Application by AQUIND Limited for an Order granting Development Consent for the AQUIND Interconnector Project

Agenda for Issue Specific Hearing 2 dealing with matters relating to Traffic, Highways and Air Quality (ISH2)

Plate 1 - Typical Laydown Area Dimensions

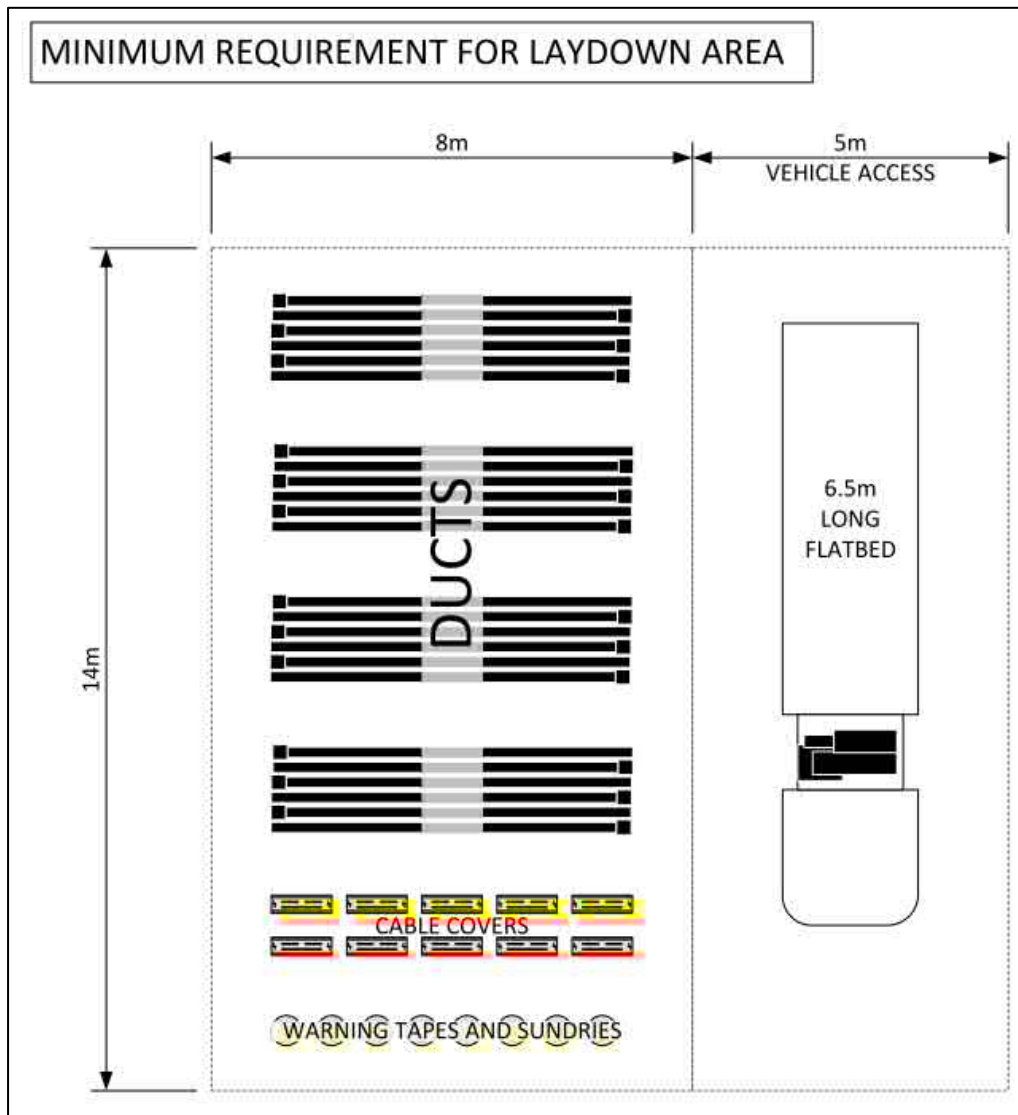
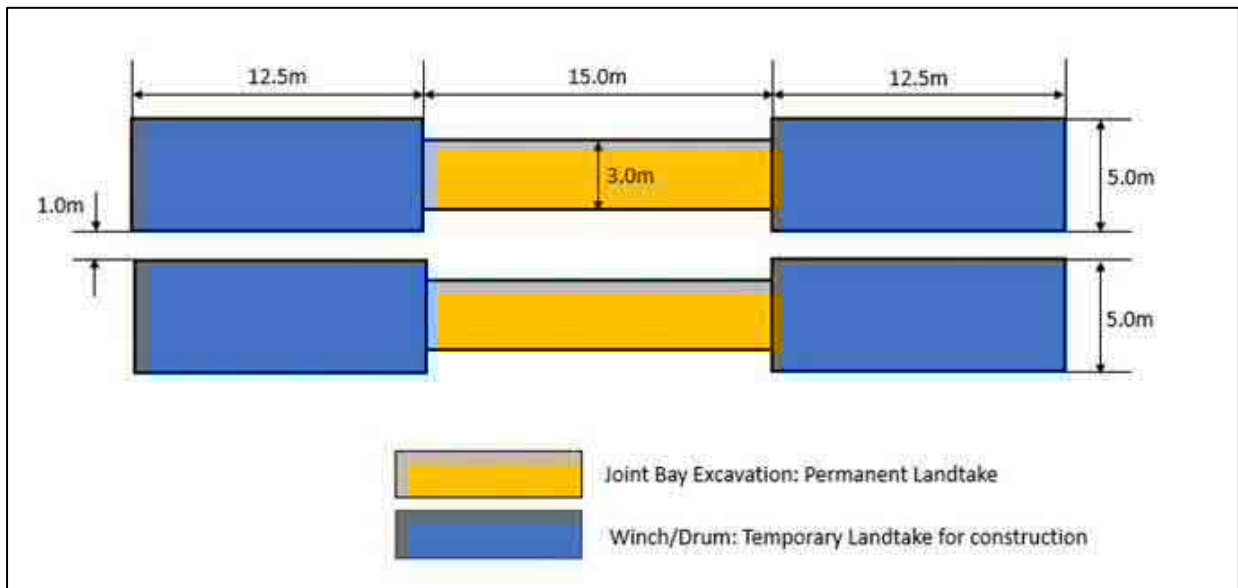
- Given the Applicant's response to Local Impact Reports ([REP2-013], page 3-50, 5.5.2) regarding the position of joint bays, and noting that the construction of a joint bay takes 20 days, what confidence can the highway authorities have that the construction of joint bays will not take place within the highway?
- Has the Applicant modelled the worst case of all joint bays needing to be constructed in the highway on Portsea Island? If not, why not?
- Given the extent of the Order limits, how does the Applicant intend to provide laydown areas adjacent to construction works without encroachment onto the public highway?

Appendix 2 – Converter Station Access Drawing

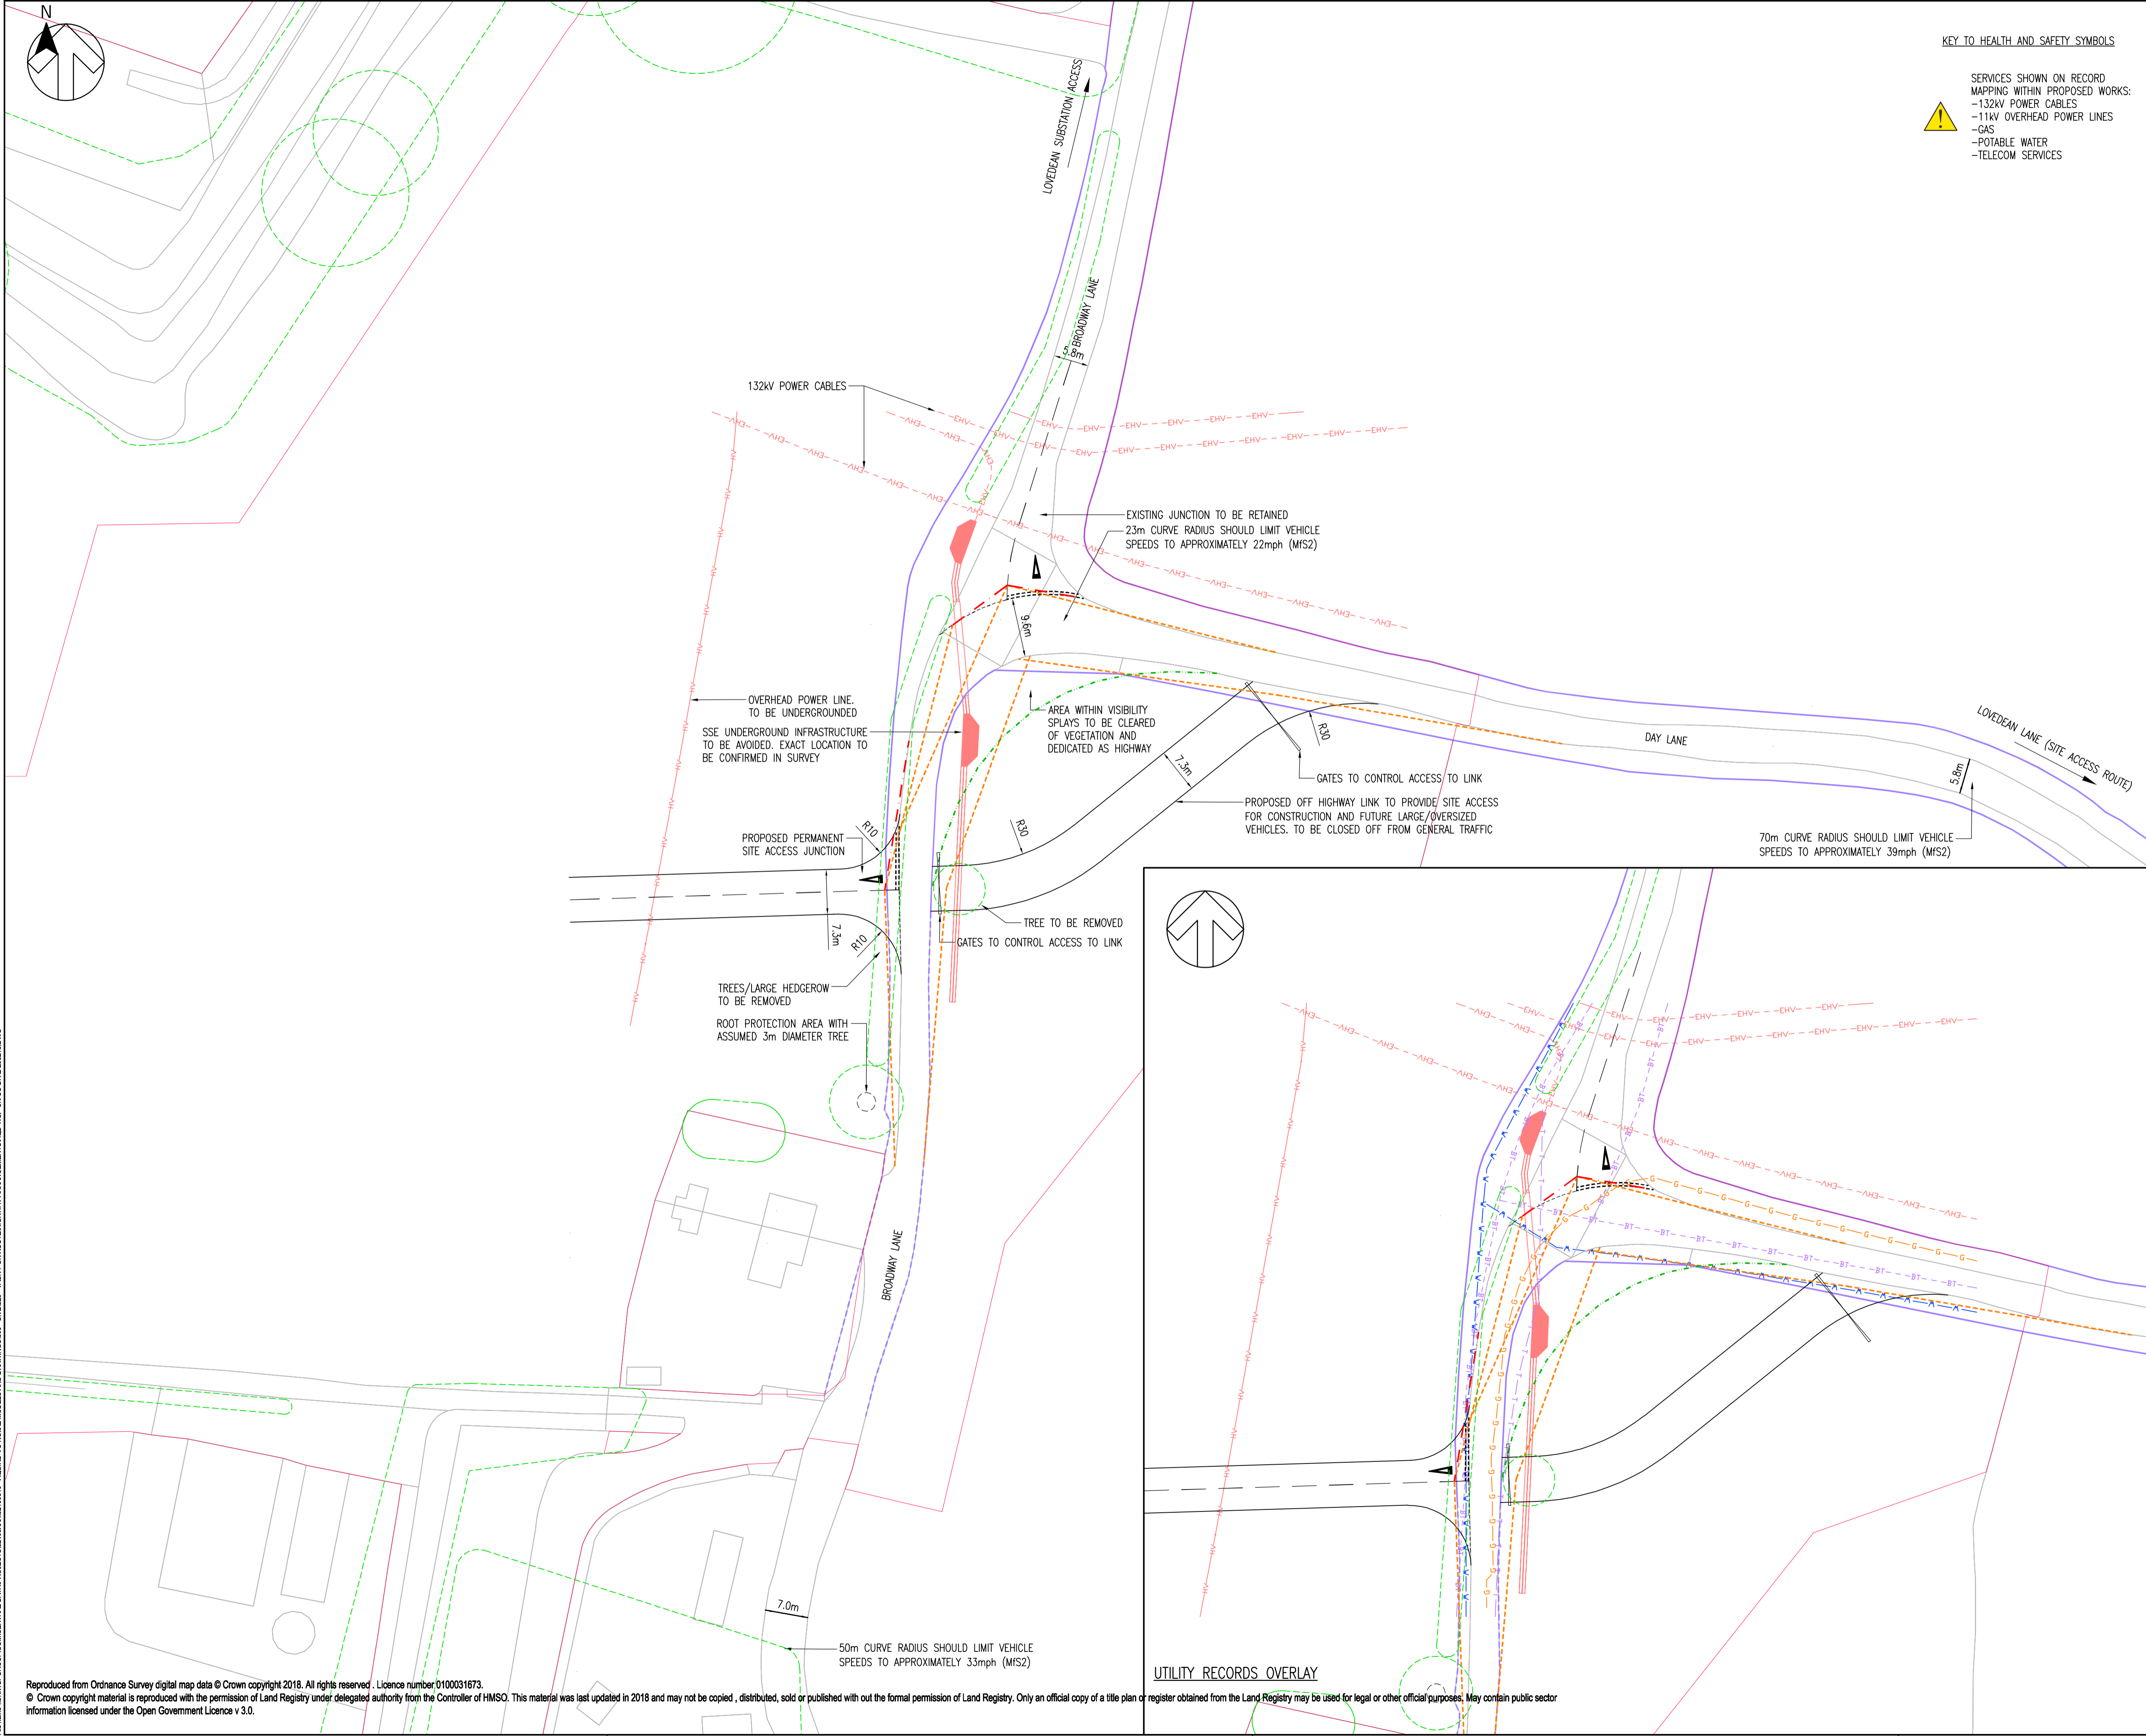
- At Day Lane and Broadway Lane, why can't normal construction vehicles (i.e. non-AILs) utilise the existing highway network without modification, especially since option 1 (shown in Appendix 5 to Appendix F of the Transport Assessment [APP-448]) shows that even AILs may be able to use the existing highway with minor modification? If option 1 (reference above) is not feasible, why not?

- Is there a compelling reason why option 1 cannot be pursued and that option 2 (with permanent acquisition of land) has to be followed?
- With respect to management of construction traffic on Day Lane, can the Applicant set out the predicted effectiveness of using banksmen to co-ordinate HGV movements? Apart from the purpose-built access on the corner with Broadway Lane, how does the Applicant intend to prevent HGVs meeting other non-construction traffic and potentially waiting within the public highway?

- Does the Applicant consider additional passing bays or waiting areas to be required on Day Lane and Lovedean Lane? If not, why not?
